Appeal Decision

Appeal Ref: APP/C3105/W/20/3253999

Banbury Service Station, Oxford Road, Bodicote OX15 4AB

- The appeal is made under section 78 of the Town and Country Planning Act 1990 against a refusal to grant planning permission.
 - The appeal is made by Mrs Natalie Ternent of Euro Garages Ltd against the decision of Cherwell District Council.
 - The application Ref 20/00167/F, dated 23 January 2020, was refused by notice dated 19 March 2020.
 - The development proposed is described as a 'retrospective planning application to retain storage container to rear of petrol filling station kiosk.'
-

Drawing No: **PLN.023.01.A2.EC**
Scale: **1:500 & 1:1250 @ A2**
Issue Date: **22/01/20**
Drawn: **EC**
Checked: **IS**

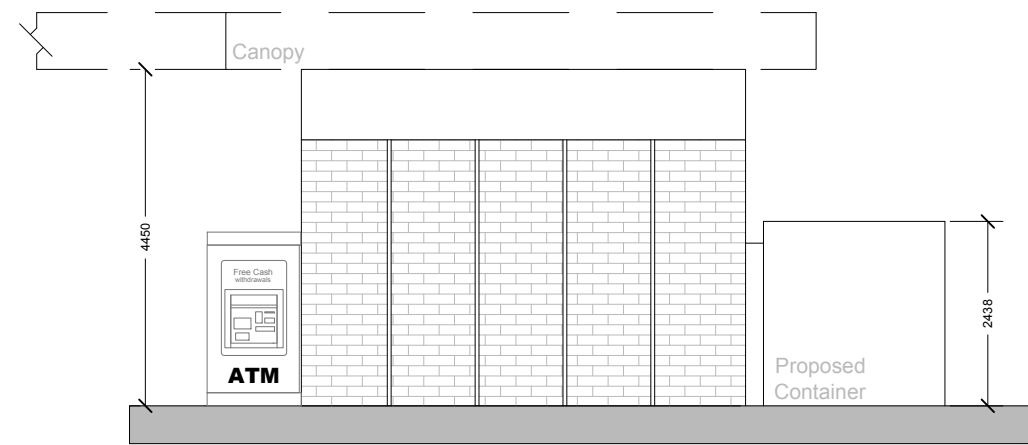
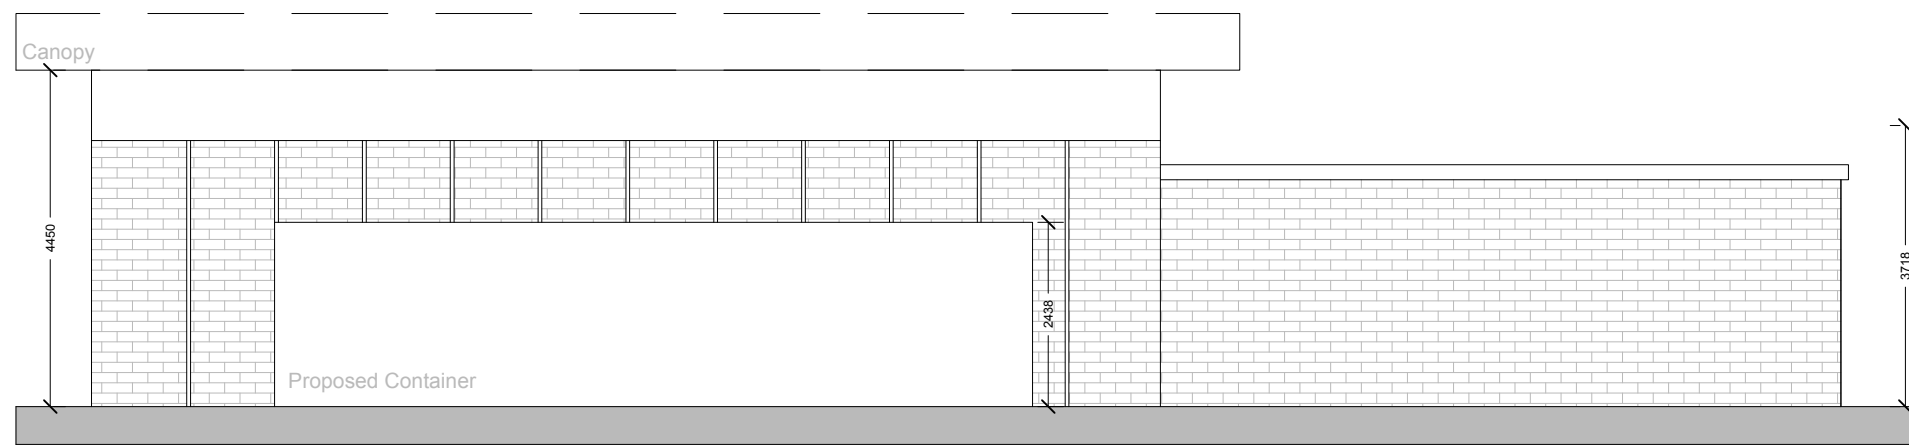
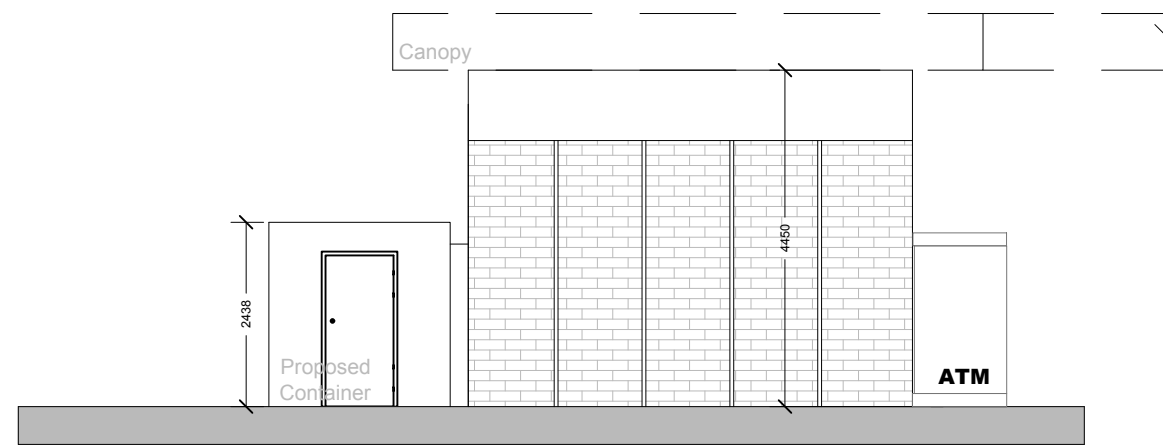
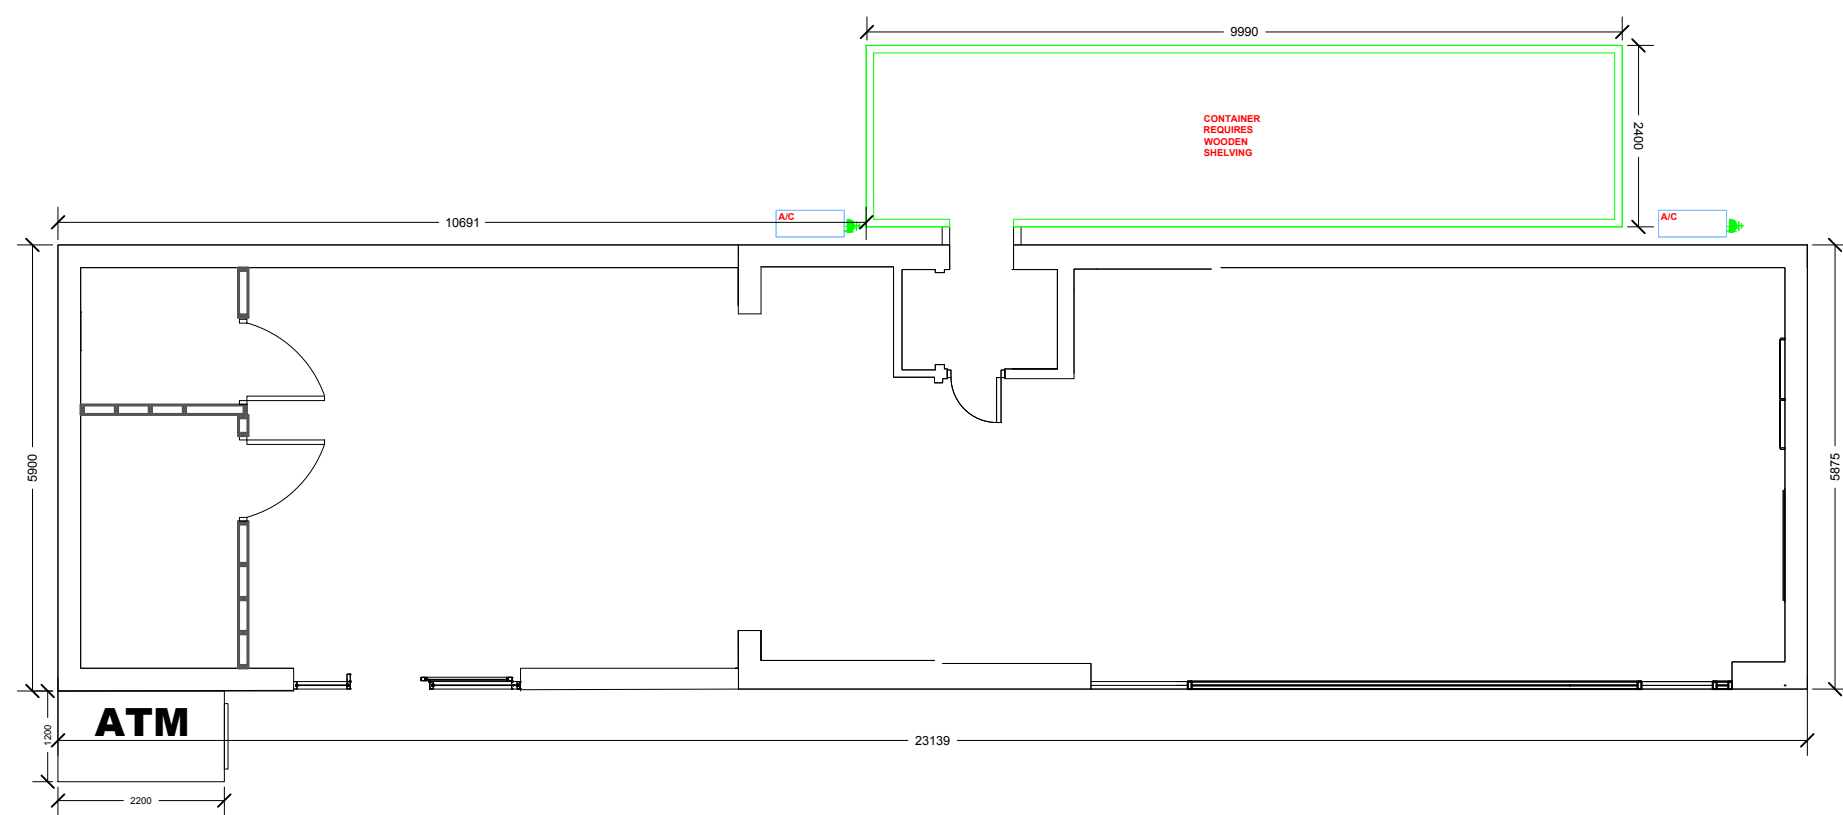
10. The appellants suggest a condition could be imposed to require a replacement 2m high timber fence screen along the south eastern boundary. However, the height of the container² would be greater. Therefore, the fence would provide only partial screening and consequently, would not entirely overcome my concerns.

² 2438mm on drawing no.PLN.023.01.A2.EC
